An
Bord
Pleanála

Inspector's Report ABP-303810-19

| Question | Whether a portal frame shed for agricultural usage, 5.07m in height and site boundary revisions is or is not development or is or is not exempted development. |
| Location | Coolfore, Monasterboice, Co. Louth. |

REVISED BOUNDARY SITE PLAN.

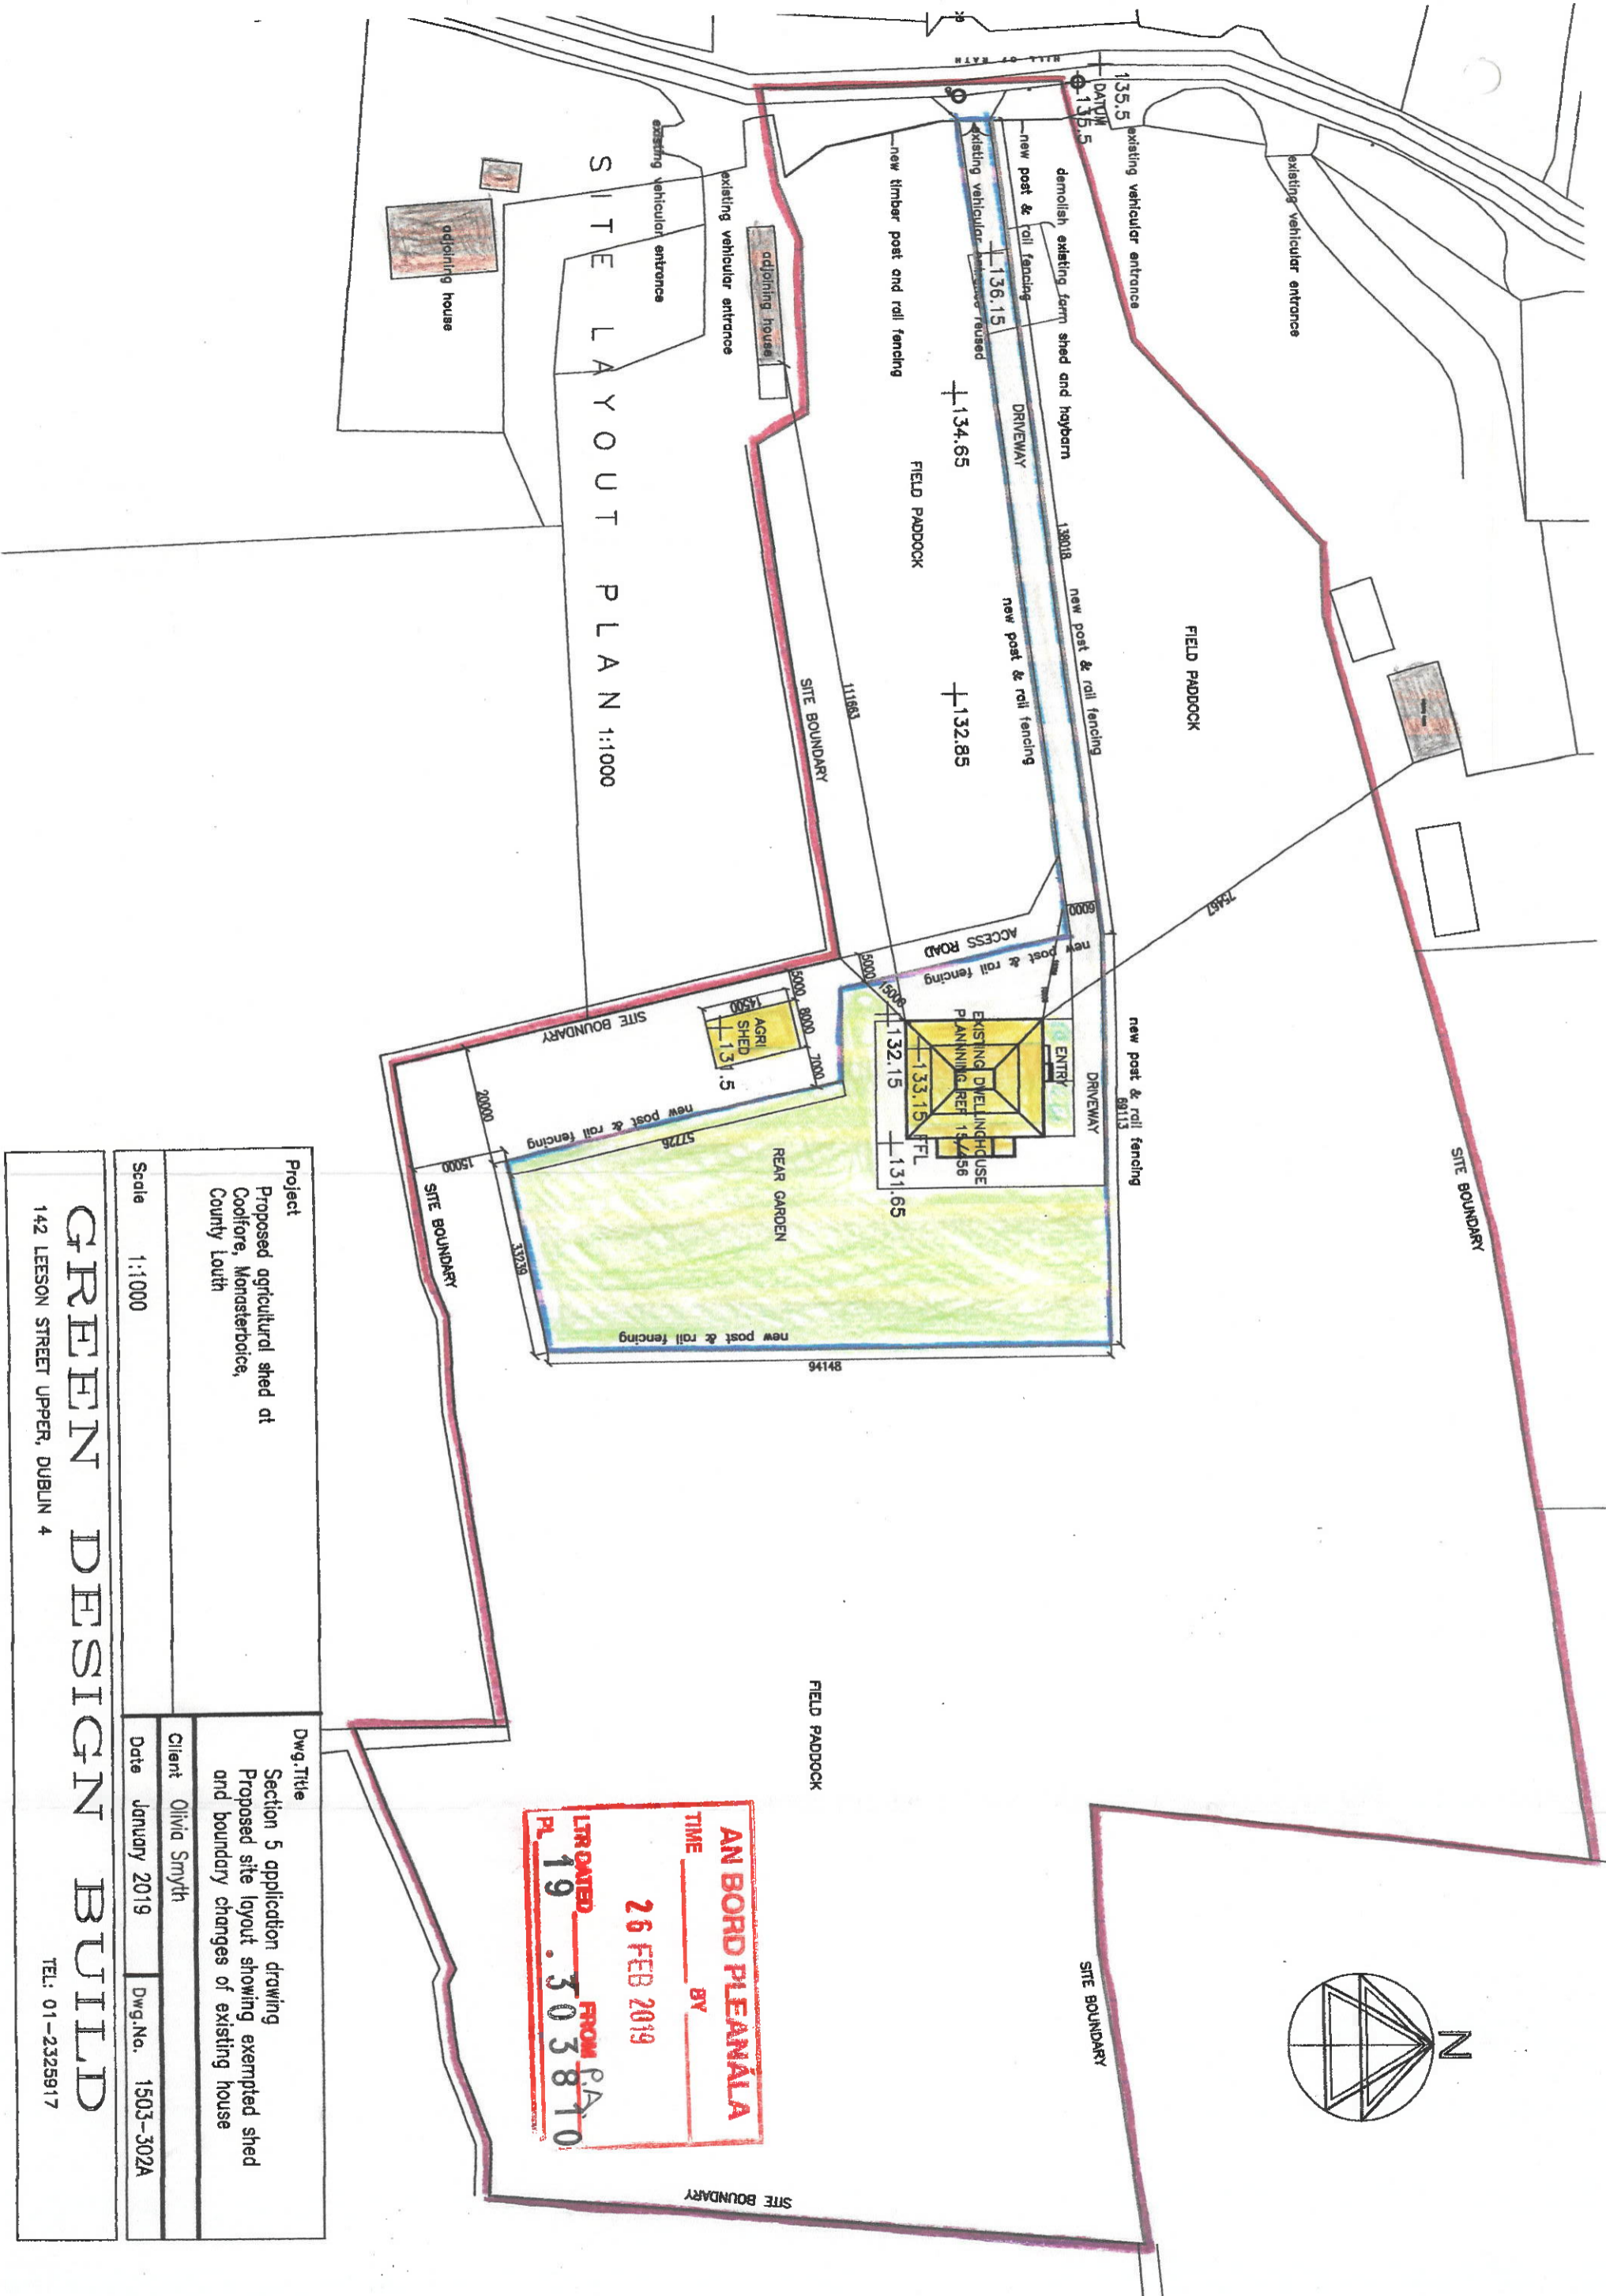
- 8.2.1. This referral before the Board differs from that previously submitted, in that the applicant proposes to (a) revise the folio arrangements for the subject site, to remove it from the folio associated with the residential property, and (b) provide fencing along the perimeter of the residential property and separate it from the agricultural shed. It is also argued that the subject shed comprises a building within a dispersed cluster, being 90m from the yard to the rear of the existing agricultural building at the entrance to the subject site.

- 8.2.2. At the time of site inspection, the existing residential property and subject shed share the same access driveway, the proposed site boundaries were not in place and the subject shed was physically removed from any nearby farm buildings/complexes. Furthermore, the yard referred to by the referrer was not apparent to the side or rear of the existing agricultural shed (to the west of the site) and the area was not demarcated in anyway (it appeared to comprise part of the sown agricultural field – see photograph 1). There is therefore, in practice, no clear separation of land uses, and the two structures would appear to be in common/collective usage.

- 8.2.3. Notwithstanding this, planning permission was granted under PA ref. 15456 for a residential property on the subject site. It included a rear garden area to the south of the property (see copy of drawing no. 1503-301 on file). The proposed shed has been constructed in the defined curtilage of this residential property. In the absence of planning permission, neither the artificial separation of the overall landholding into

two separate folios or the erection of timber fencing to separate the uses change this planning status. The referral must therefore be adjudicated upon, on this basis.

Green Design Build		142 Upper Leeson Street, Dublin 4	
142 Upper Leeson Street, Dublin 4		Tel: 01-232917	
Project	Retention of built agricultural Shed - Coofore, Monasterboice, Co. Meath	Scale	1:200
Client	Fergus Nellie	Date	Dec 18th
Drawings	Elevation Drawings	File	Client

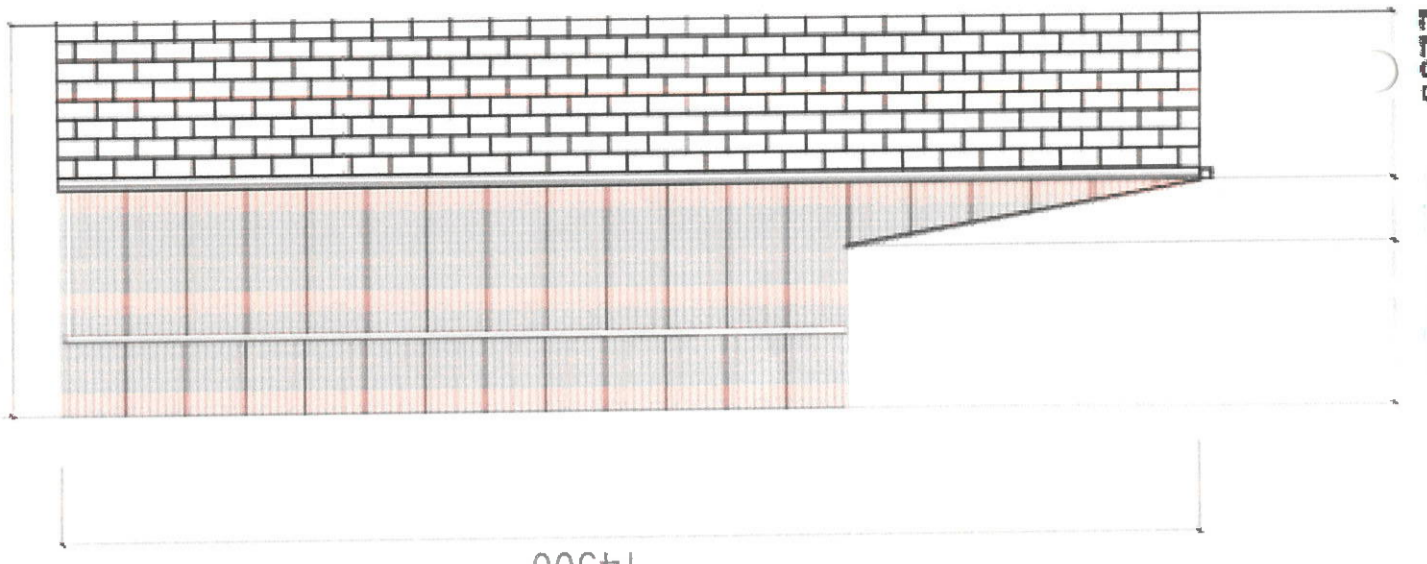
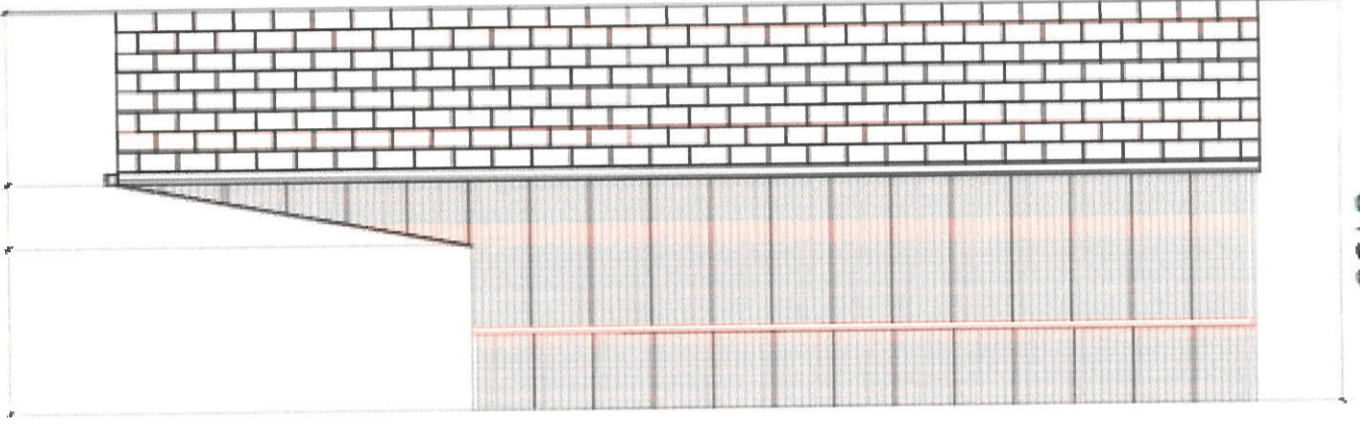
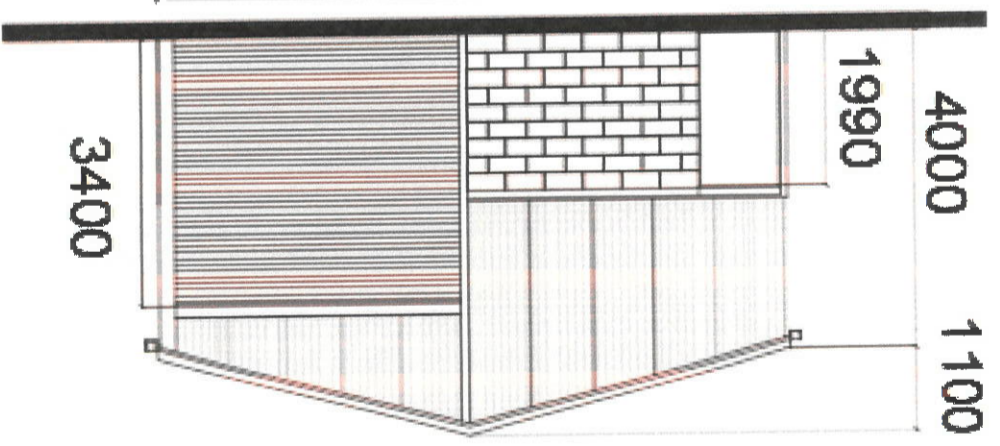
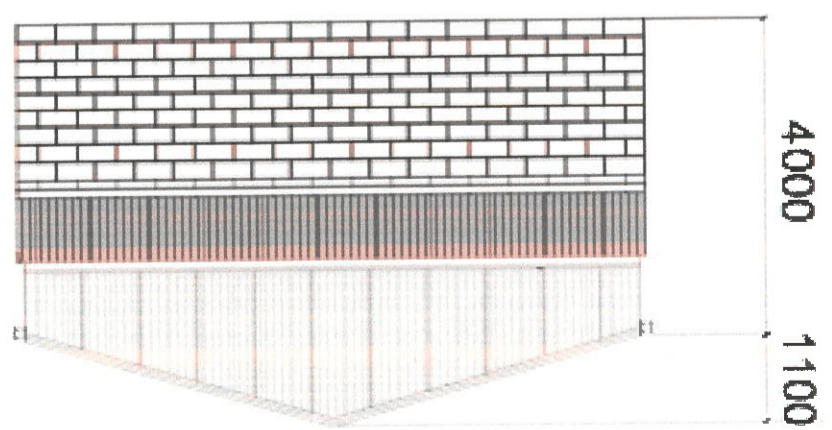
The area of the building in question exceeds 25 square metres, the external finishes and roof covering of the building do not conform with those of the house, the height of the building exceeds three metres, the

building is used for a purpose other than incidental to the enjoyment of the house, and
